**Consultation Response from KC Landscape**

<b>Application No:</b>	2023/92490
<b>Proposed Development:</b>	Erection of 38 dwellings with associated access and landscaping (within a Conservation Area)
<b>Location:</b>	Former Dowker Works, Dowker Street, Milnsbridge, Huddersfield, HD3 4JX
<b>Applicant/Agent:</b>	BTP Architects
<b>Planning Officer</b>	RichardA Gilbert
<b>Date Responded:</b>	26.09.23
<b>Responding Officer:</b>	EM
<b>Responding Ref:</b>	MM85

- Landscape Context and Concept, Landscape Design : Plans considered:
  - Landscape proposal Dwg no. 7151.01 dated July '23
  - Proposed site plan DS-BTP-00-SP-DR-A-4016\_105.1 dwg no. 105 rev 1 dated 11.08.23

Proposed Site Plan
1 : 200

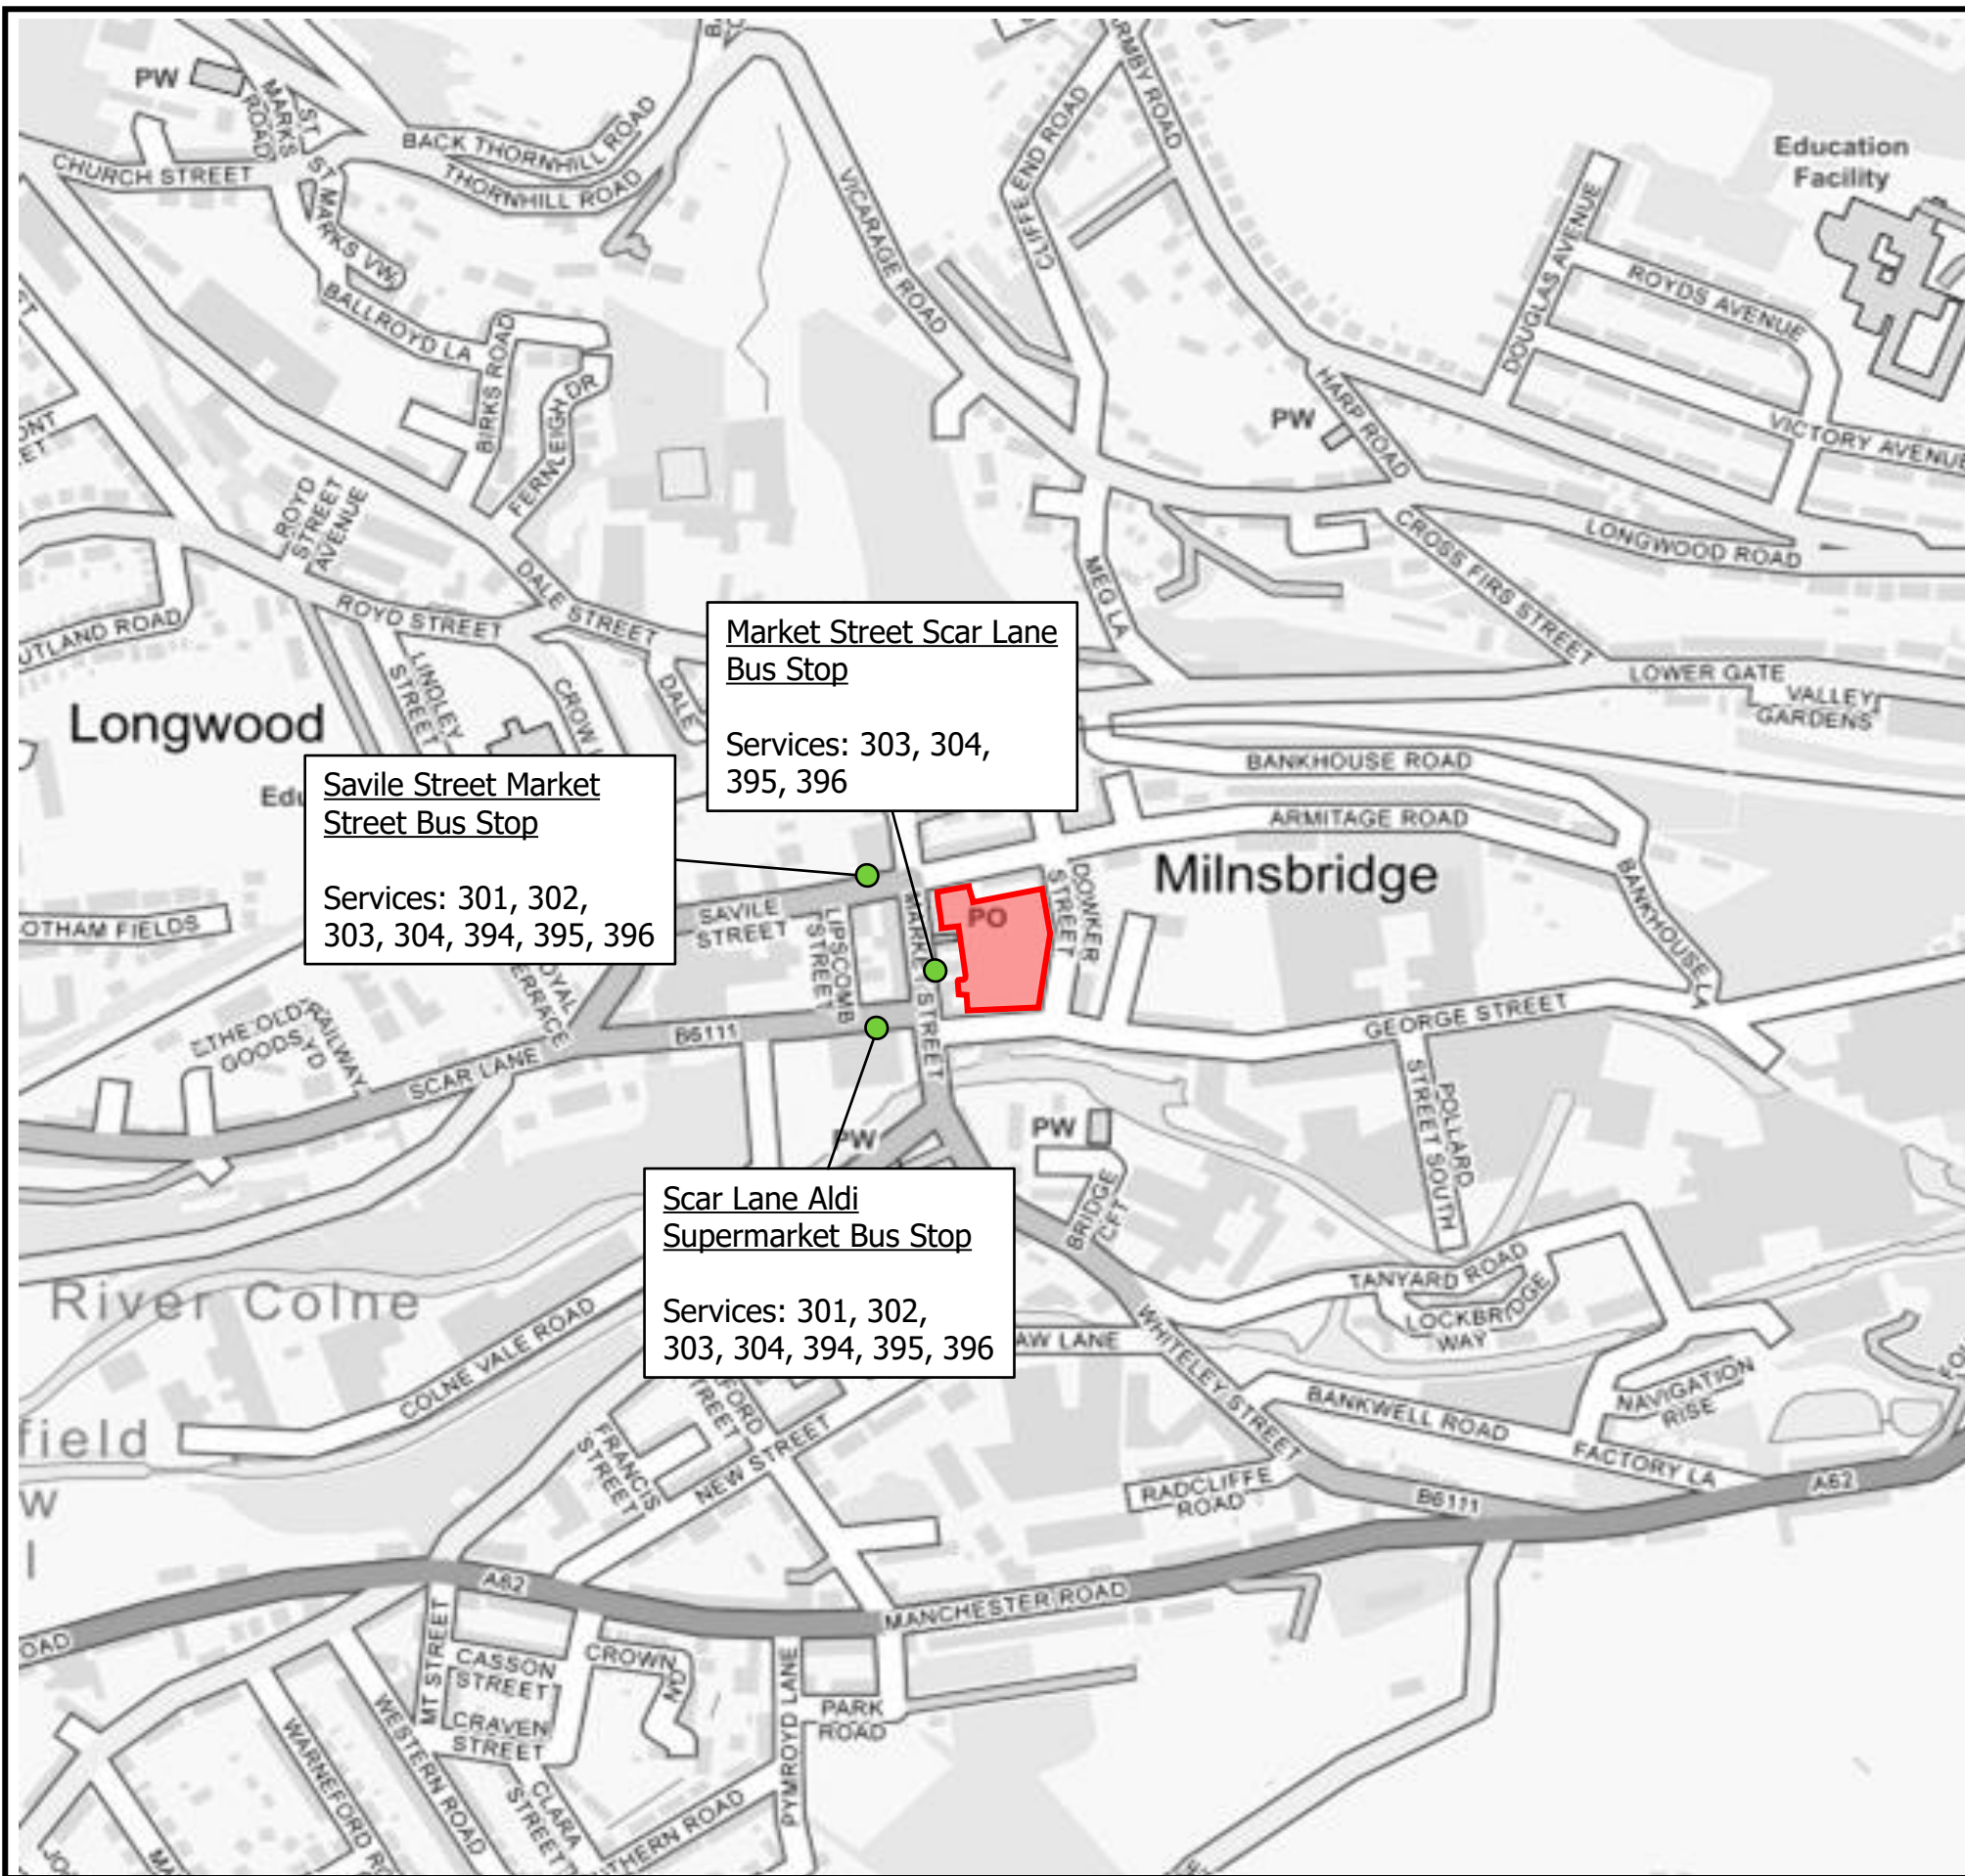
- quantities, the Ecological appraisal refers to 13 proposed trees to be included in the proposal but we have seen the landscape proposals dated July 2023 do not show the revised layout from August 23 which has a proposed bin store on the landscaped open space. The calculations will need to reflect the revised proposed planting and tree planting numbers now, some of the shrub planting and hedgerow planting has been removed for paths bins etc..

4. The plan is very indicative in terms of what any communal open spaces or landscaped planting areas are to be used for, therefore difficult to provide meaningful comments, however, the greenspace on site shown is welcome, however, consider access and purpose of the spaces being created. And which plans are the actual ones for green space, are there the bin stores on the green areas now?

8. The scheme as a whole is ok but is in the Conservation Area and currently does not provide street tree planting for the development which would be preferred. Trees in rear or private gardens cannot provide the same public amenity and tend to be removed before they reach a size that allows them to contribute to the setting of the development however we appreciate that sufficient space is limited. Please also be reminded of the council's advice regarding Green Streets principles, as well as paragraph 131 of the NPPF, which requires new streets to be tree-lined.

**Revision of landscaping plan to reflect bin stores**
